State Significant Development SSD 9494 – New School in Wagga Wagga

Response to Agency Submissions

Figure 1: Revised Proposed Layout

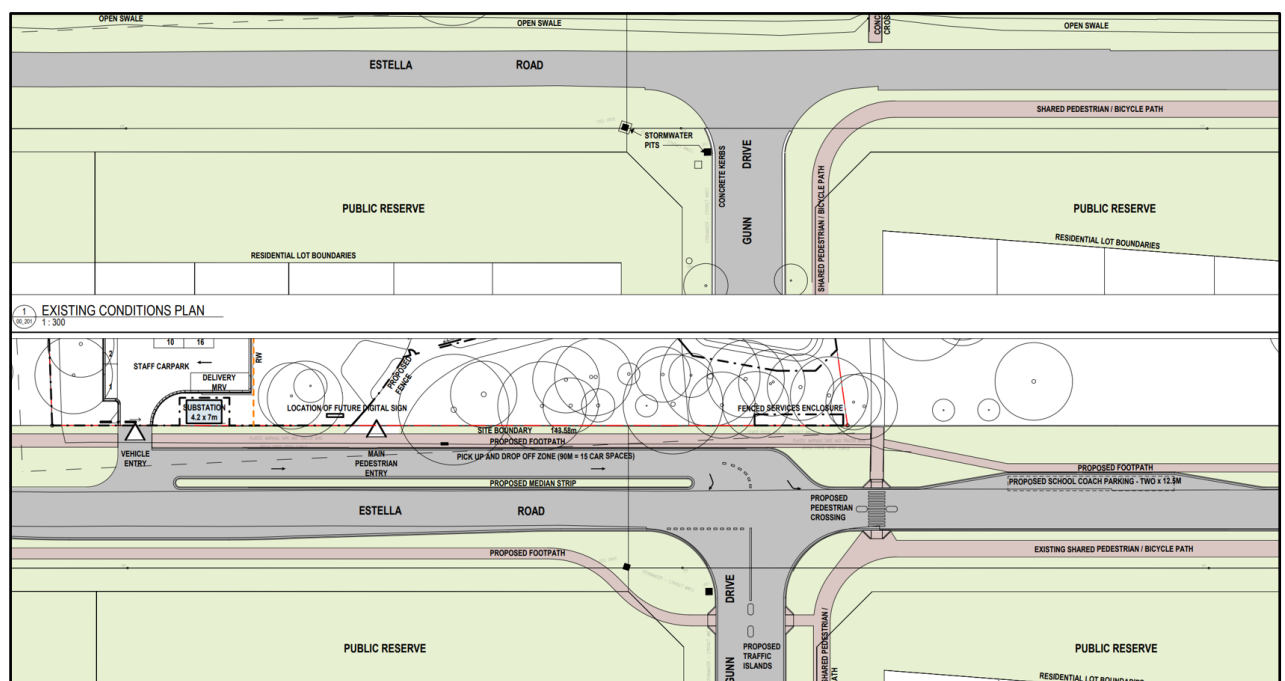
6	Confirm whether vehicular access is proposed long the existing path to the east of the site in consideration of the comments made by Charles Sturt University.	Vehicle entry is only via the Estella Road entry. No vehicle access is proposed by the east of the school.
7	Transport Provide information to demonstrate that the proposed drop-off and pick-up facility would adequately cater for demand, particularly in the afternoon peak which experiences longer dwell times as recognised in the TAR, to avoid queues onto,	In consultation with Council the design of the Estella Road frontage has been amended. The revised, proposed layout of the school frontage on Estella Road (see Appendix B) has been modelled in SIDRA using inputs provide by Council and based on Wagga Wagga Spatial Plan 2013/2043. The revised layout consolidates the Drop-Off/Pick-Up Zone

WAGGA WAGGA PS
ESTELLA ROAD, ESTELLA, NSW, 2678
NEW HIGH QUALITY CLASSROOMS PACKAGE 2
DRAWING NAME
FENCING PLAN & DETAILS

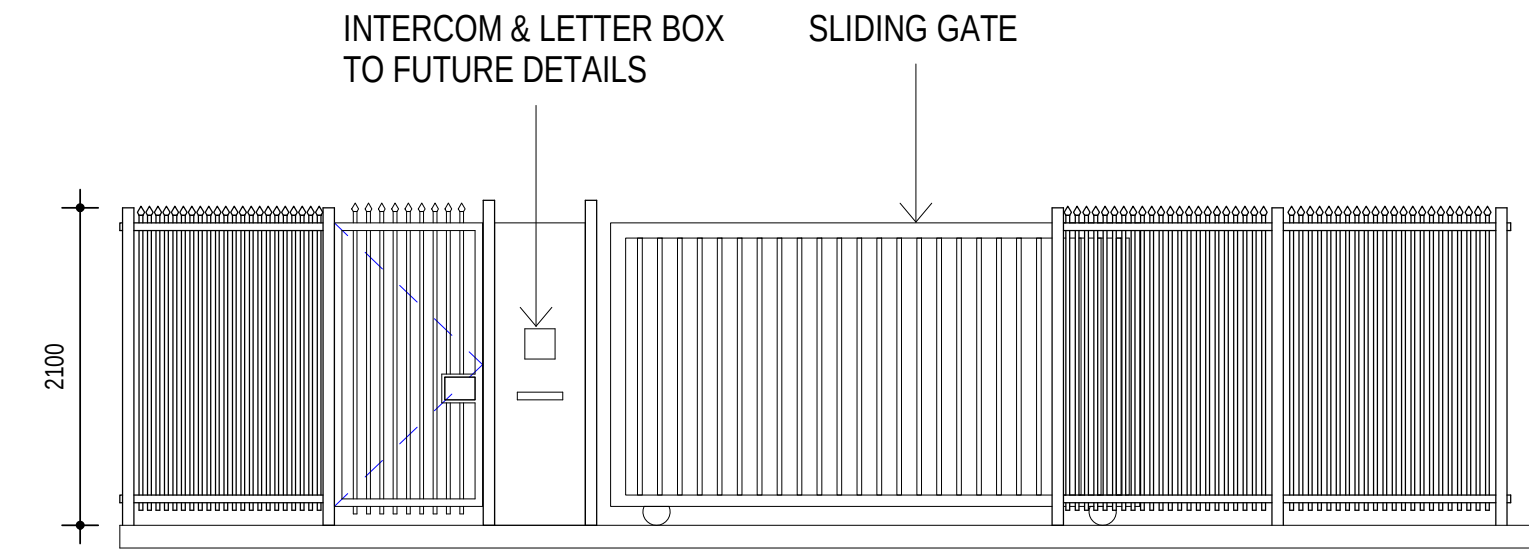
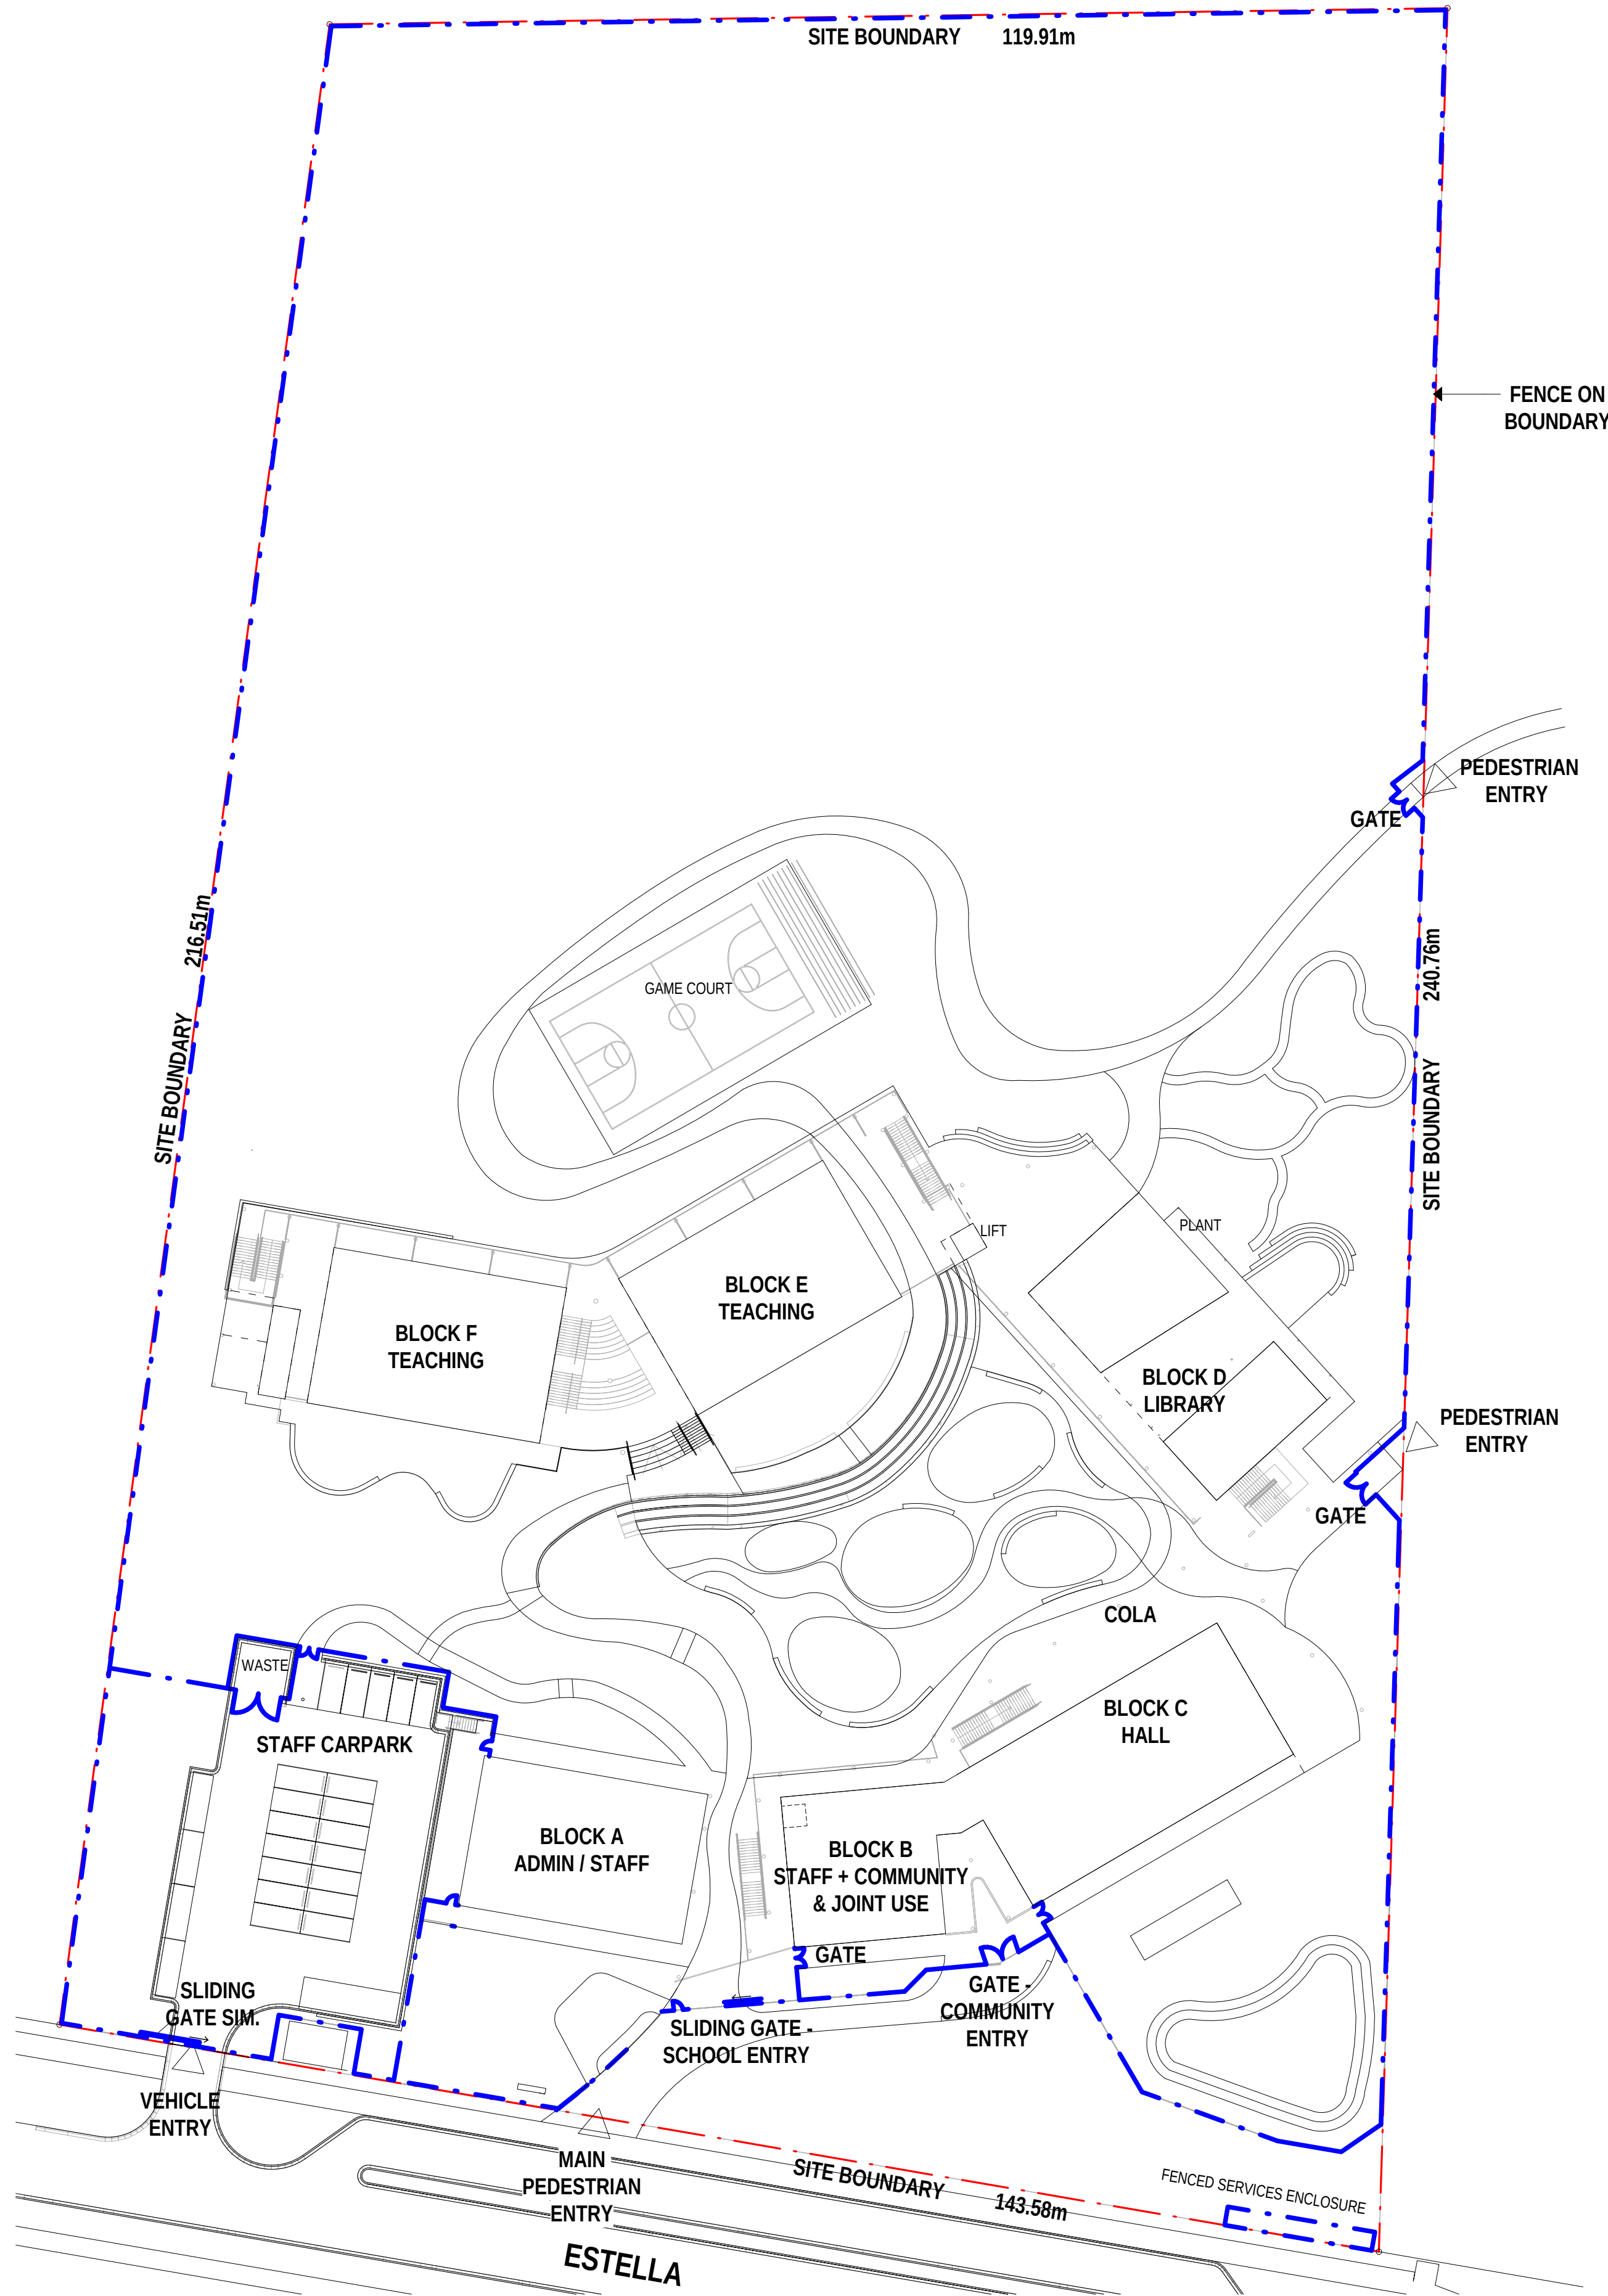
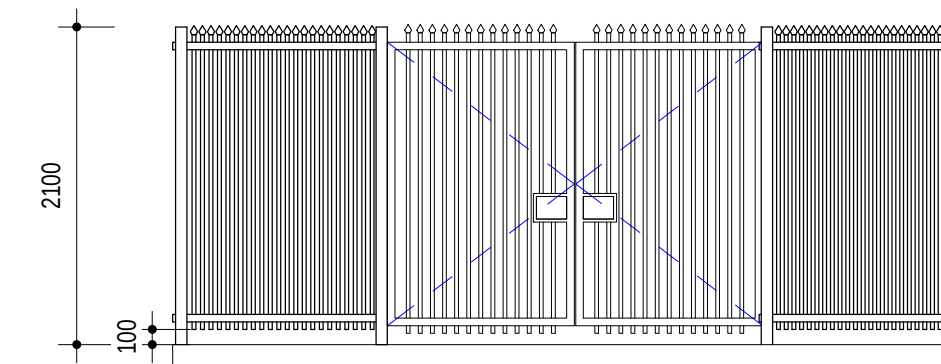
Number	Submission	Response
Department of Planning, Industry and Environment		
1	General Provide an updated Aboriginal Cultural Heritage Assessment Report that includes correct mapping of Aboriginal Heritage Impact Permits (AHIP) in consideration of comments made in the submission lodged by the Environment, Energy and Science Group of the Department.	Please refer to the response to Biodiversity and Conservation Division (of the Department of Planning, Industry and Environment) provided below.
2	Provide further details of the proposed fencing of the site, including the location, height and type of fencing, and demonstrate that this is suitable to the open rural character of the location.	The SINSW School Security Unit have confirmed that the school requires a standard 2.1m high school fence. A separate fence plan including a front fence elevation showing the sliding gate and pedestrian gates is provided as part of the amended drawings at Appendix B .
